A303 Amesbury to Berwick Down

8.4(2) – Statement of Common Ground –National Farmers Union
(TRACKED CHANGES)

A303 Amesbury to Berwick Down
Development Consent Order ~~2019~~[20**](#)

STATEMENT OF COMMON GROUND –National Farmers Union

Drawing Title
**RIGHTS OF WAY AND ACCESS PLANS
REGULATION 5(2)(k) & 5(2)(o)
SHEET 4 OF 15**

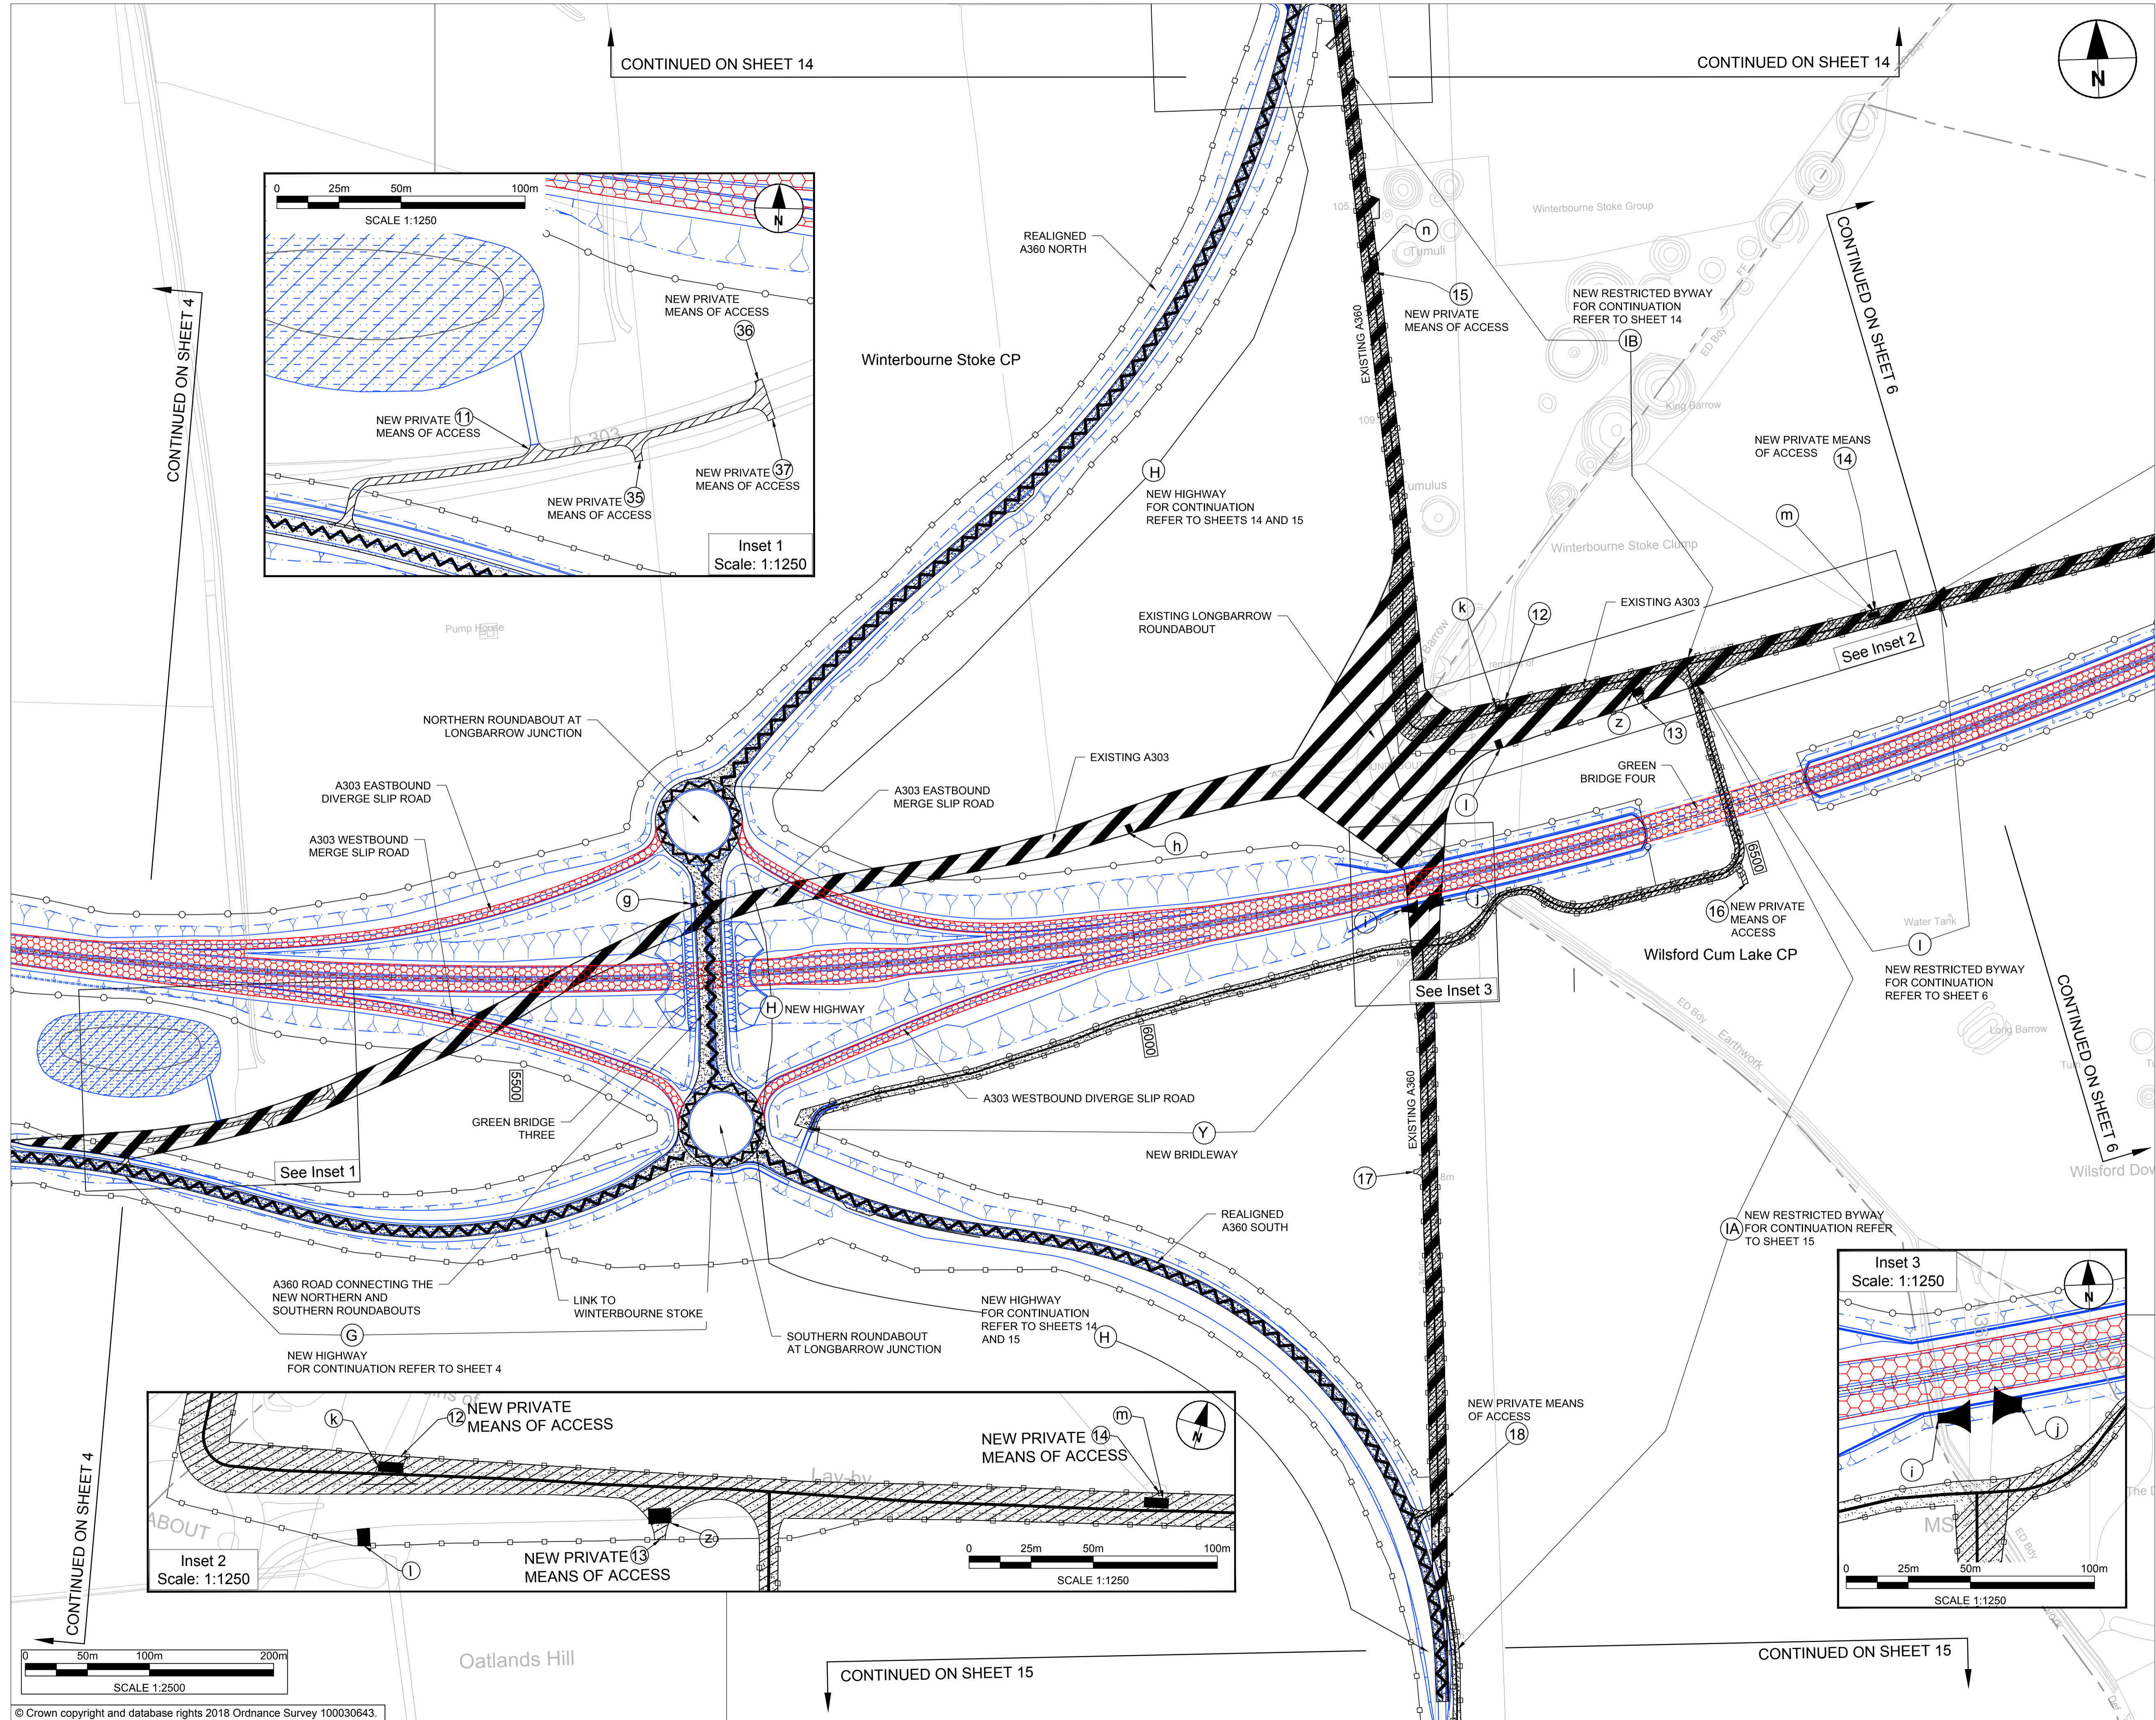
3.19	ES Chapter 11- Road drainage and the water environment [APP-049]	11.3 Assessment methodology (and Appendix 2.1)	11.3.10 – 11.3.13 Consultation	Further information is needed in regard to the size and location of the drainage infiltration. Concern: The locations are greatly interfering with farm	Following this consultation feedback, the number of drainage infiltration areas has been rationalised in the application Scheme in terms of reducing the number from	AGREED

Issue No.	Document Reference	Section/Paragraph Reference	Sub-section	National Farmers Union Comment	Highways England Response	Status
				<p>operations within fields. Solution: A new access route has been highlighted. This is not necessary and access could be created from the byway at green bridge no.2. (Turners)</p>	<p>five to four and locating them closer to the new road. Due to the reduced number, each infiltration area needs to be slightly larger to meet the storage capacity requirement and to provide permanently wet areas to create dew ponds and allow for biodiversity enhancements. Access to the infiltration pond by Green Bridge 2 on the northern side of the A303 will now be accessed from the byway. Access to the pond on the southern side of the new road, by the viaduct, will be taken from a track within the field margin. The revised proposals can be seen within APP-009 2.6 Rights of way and access plans (sheet 4).</p>
